**KIRKLEES METROPOLITAN COUNCIL
INVESTMENT & REGENERATION SERVICE**

DELEGATED DECISION TO DETERMINE PLANNING APPLICATIONS

Reference No:	2022/62/90923/W
Site Address:	5, Pastures Way, Golcar, Huddersfield, HD7 4QG
Description:	Erection of two storey side extension
Recommending Officer:	Hubert Lam

Officer Report

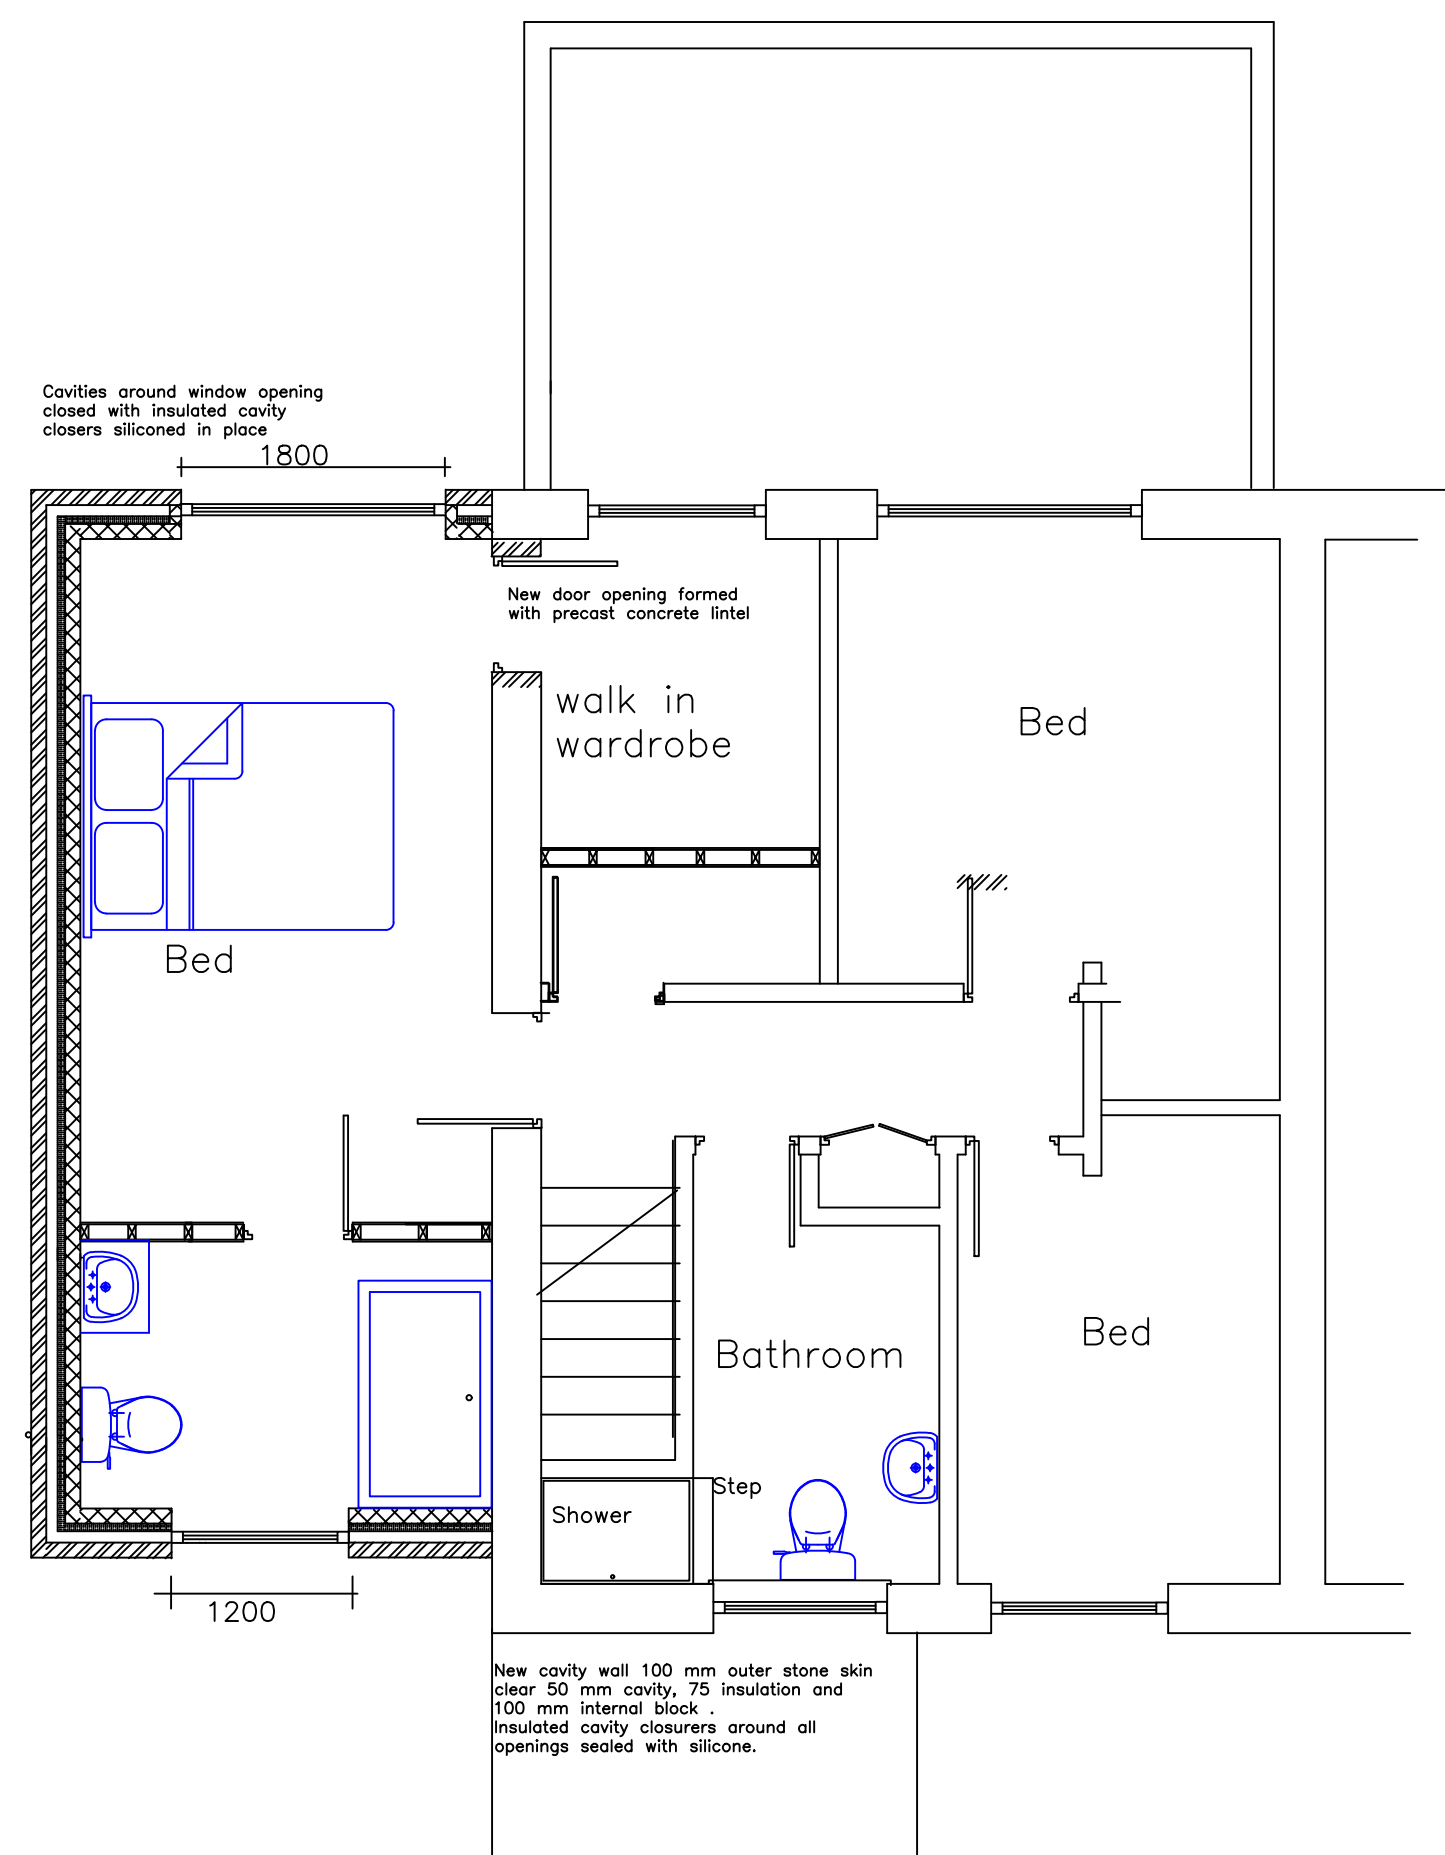
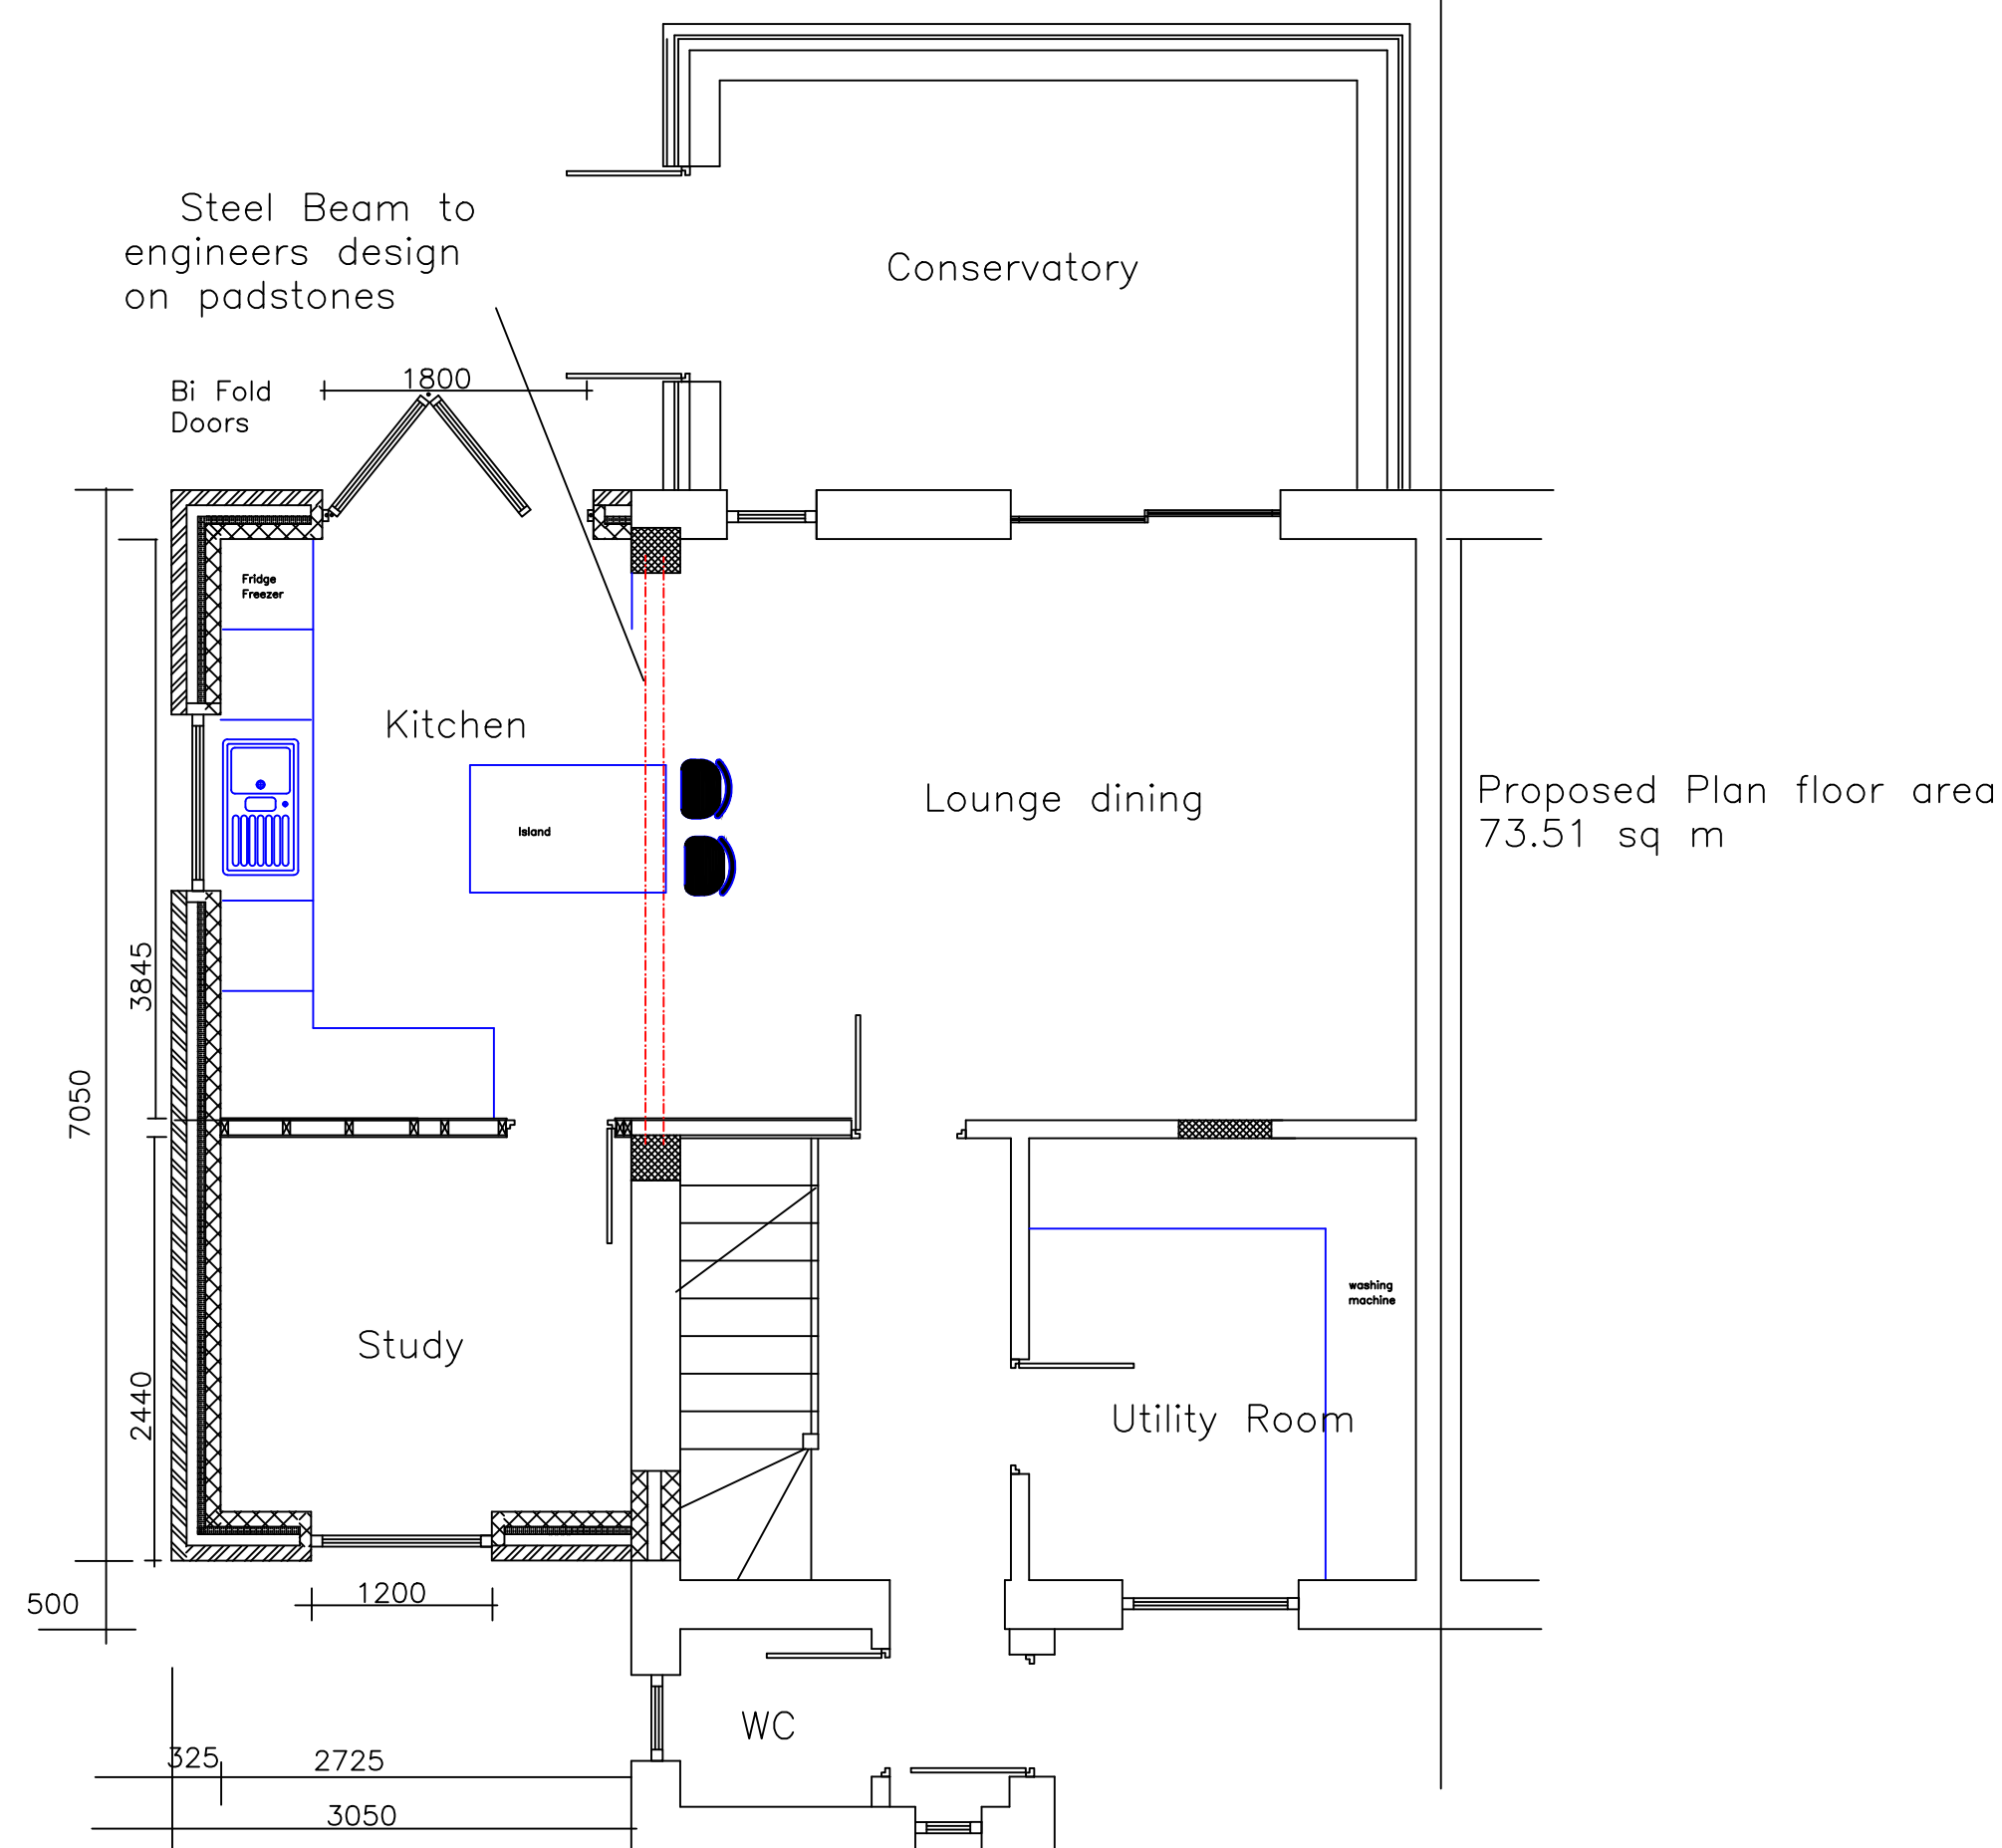
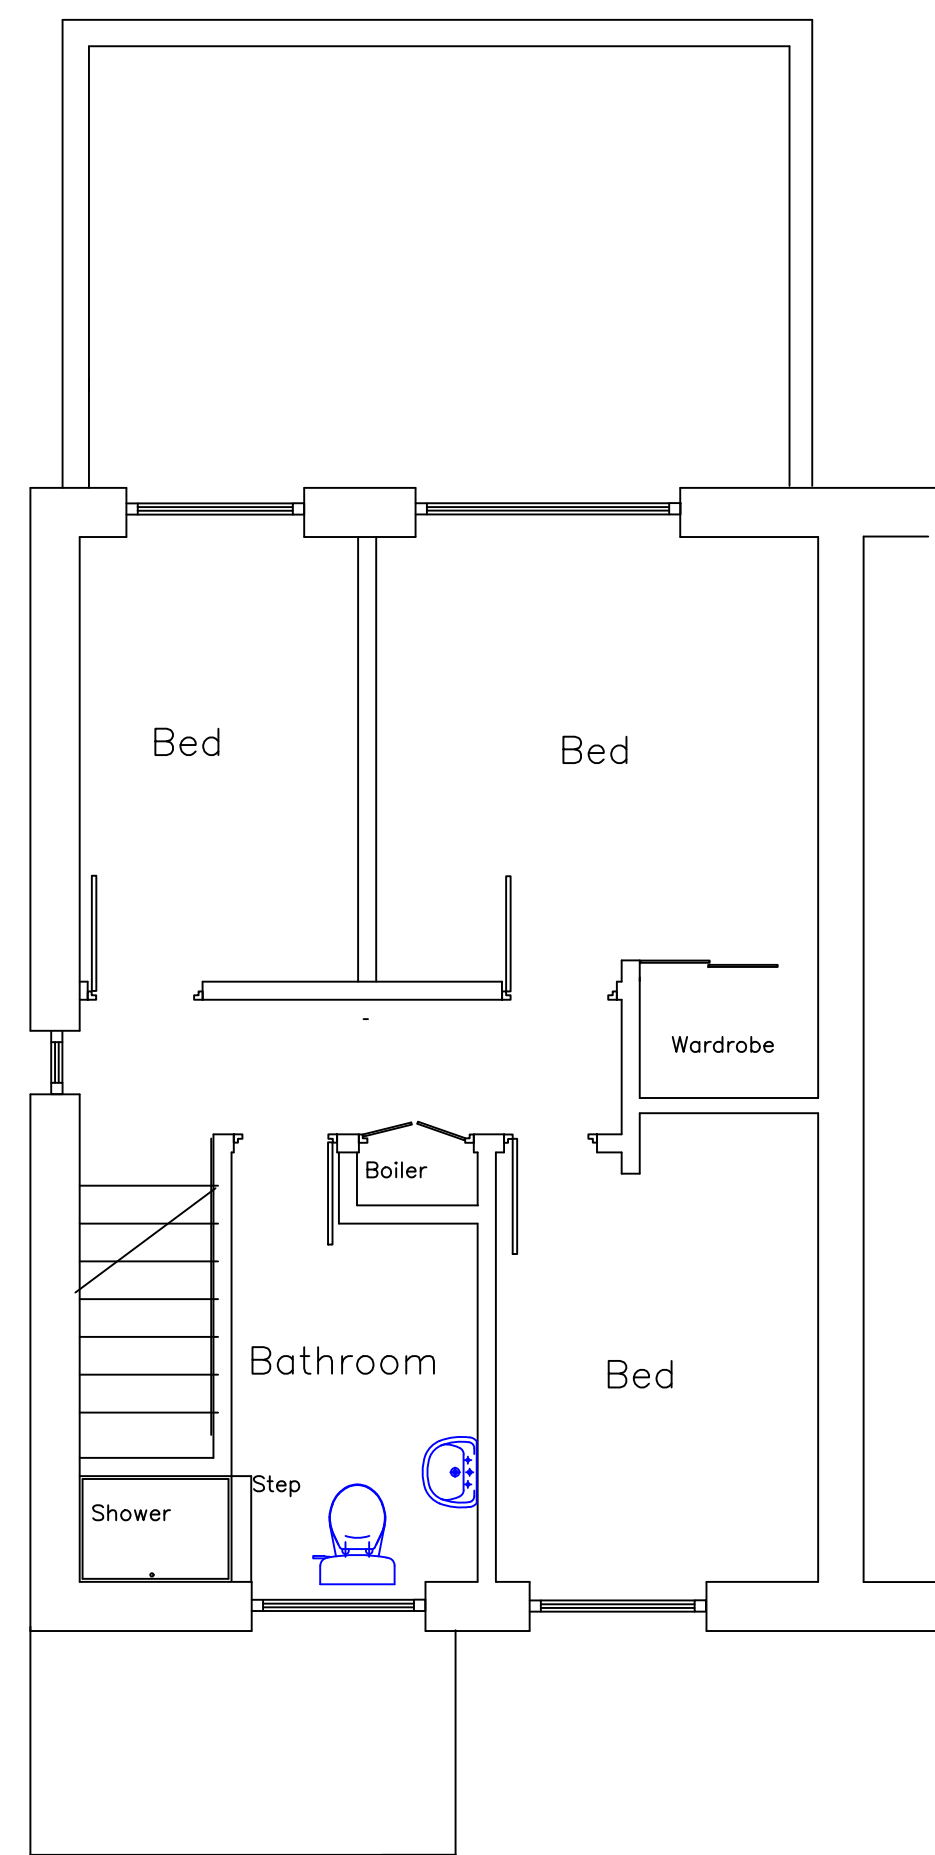
Further discussions and amendments were sought with the proposal being amended again set out in plans received 21 Jun 2022, consisting of the amended drawings NPPW/2022/02RevC, NPPW/2022/03RevC and NPPW/2022/04RevB.

These amended drawing reduced the size and scale of the proposal, including its projection from the side and also set the proposal back / down from the host property.

Further discussions have seen amended plans submitted which reduce the side projection of the proposal to 3.05m from the existing side (northwest) elevation of host property. The proposal, as amended, would maintain a separation of 5.9m from the curtilage boundary. The side to rear distance between the proposal and dwellings to the north east being 11m.

The proposed two-storey side extension, as amended, would project 3.05m from the side (northwest) elevation of the main house and would have a length of 7.05m aligning with the existing rear (northeast) elevation of the main house and set back from the existing principal (southwest) elevation by 500mm, with a dual-pitched roof section at a height of 7.8m to the ridge and 5.3m to the eaves.

The Scheme has been amended to reduce the side projection and therefore the overall width of the two-storey side extension to 3.05m, which, when compared with the initially proposed 3.85m projection from the existing side elevation, would ensure the rear to side relationship between the proposal and properties to the north would be 11m.
